From: Longridge Town Council
Sent: 14 March 2022 12:34
To: Nicola Hopkins <
Subject: RE: The Dog Inn

Application Number: 3/2021/0275

Proposal: Proposed erection of 8 new dwellings and associated works.

Location: Land Behind The Dog Inn Market Place Longridge

Planning Application  
Site Sections / Street Scenes  
Renderings  
DATE 08/03/20

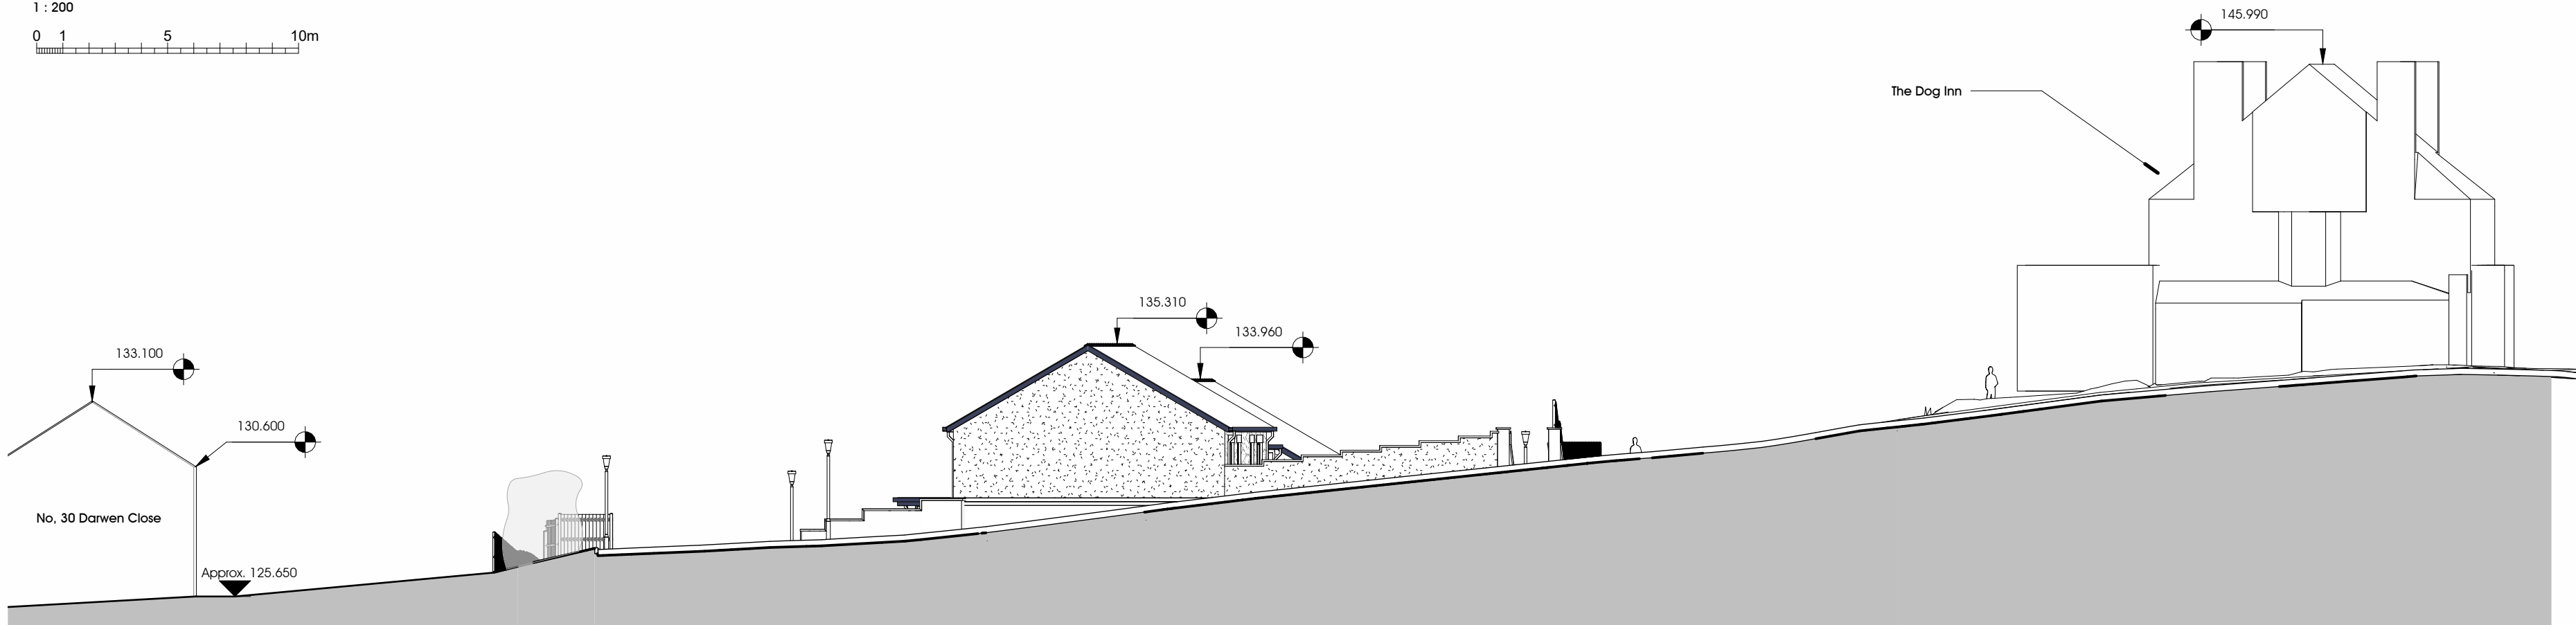
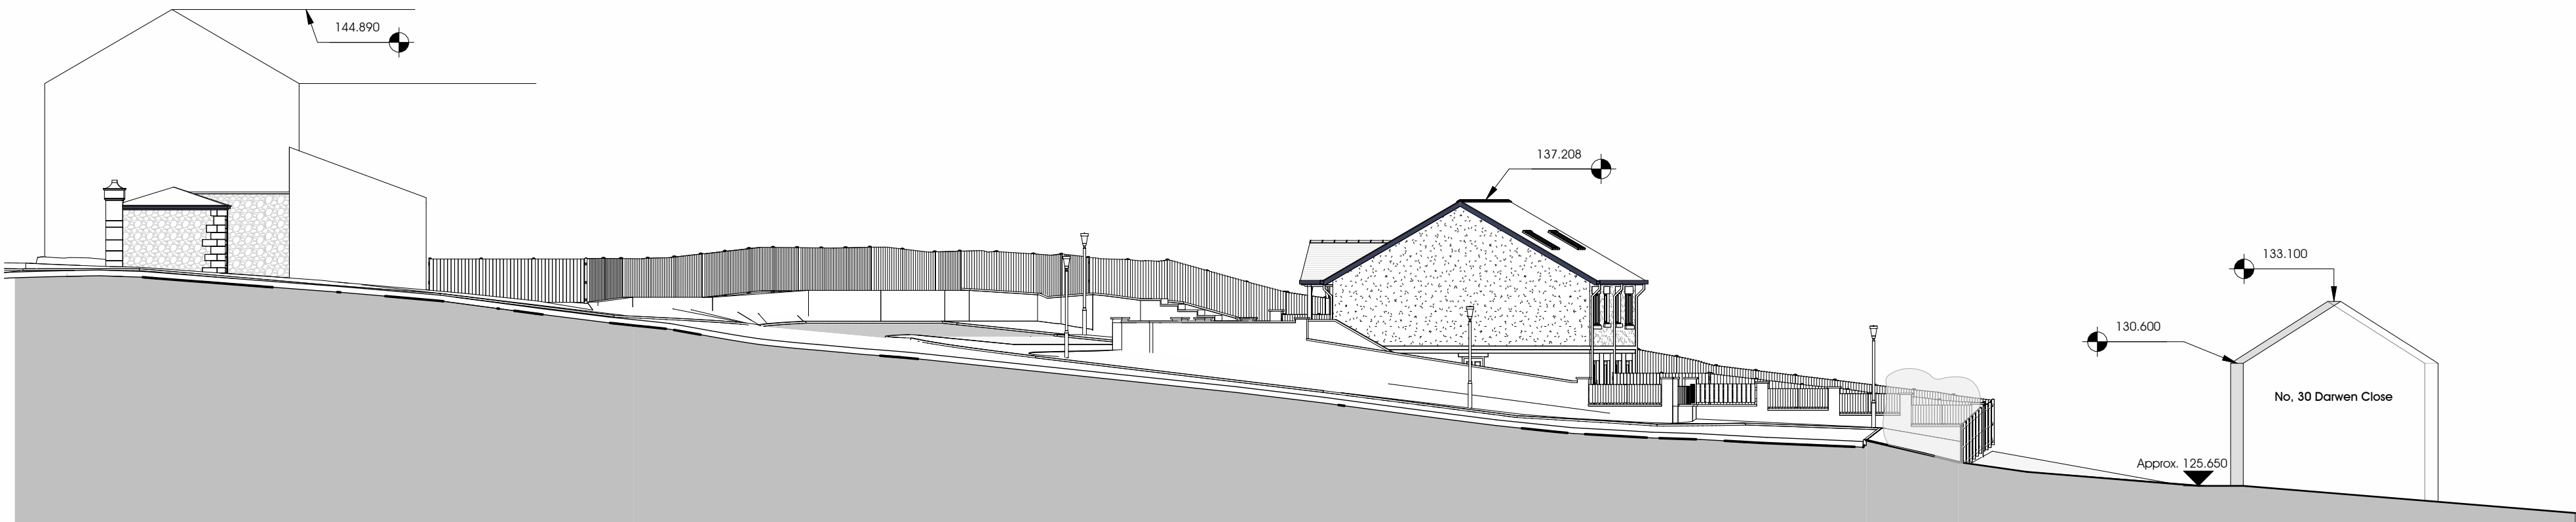
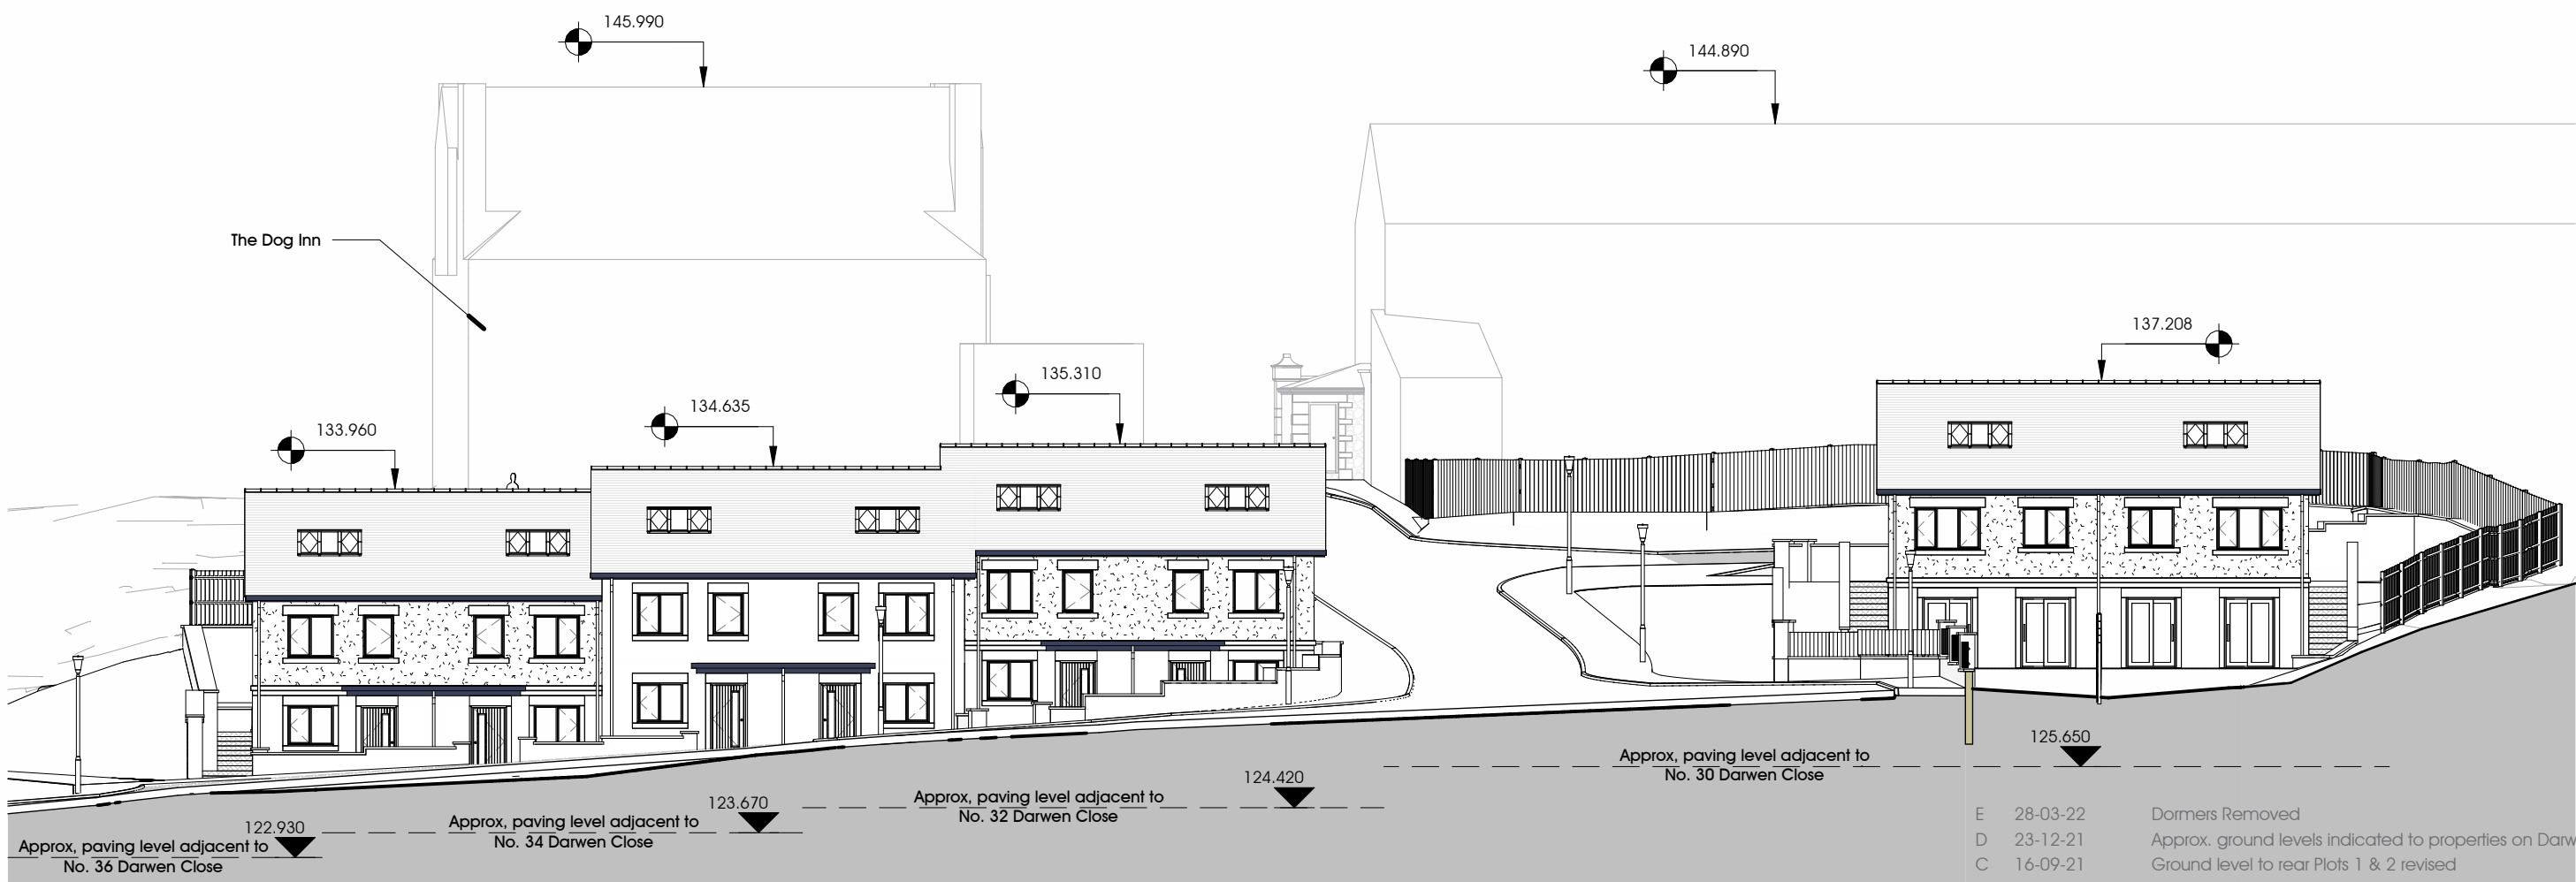
Longridge Town Council discussed the above application at their meeting on 9th February. The Council discussed the style of the buildings and commented that the use of white rendering was not in keeping with the area. The Council also asked that concerns of the residents in neighbouring properties about overlooking and privacy be taken into consideration.
